Wise Engineering
3915 Old Fairground Rd.
Angier, NC 27501
(919)894-2203

April 11, 2019

Subject: Lewis Residence – 202 Broad Lake Ln., Spring Lake, NC

I have reviewed the framing layout for the Lewis Residence. Specifically, I reviewed the Steel Beam as shown on the 2nd floor layout.

Steel Column & LVL Beam

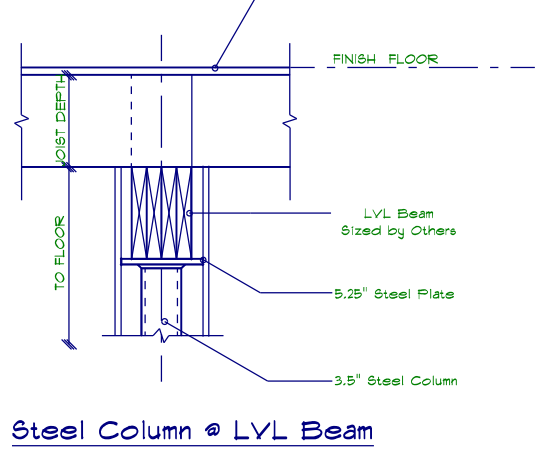
The steel beam as shown supports the roof (trusses), a wall, floor truss girders, as well as floor trusses. It spans approximately 22 ft. Based on my analysis, the beam (W16x67) is adequately sized as shown on the floor layout. It should be supported on each end with a 5 inch steel column as shown on the plans.
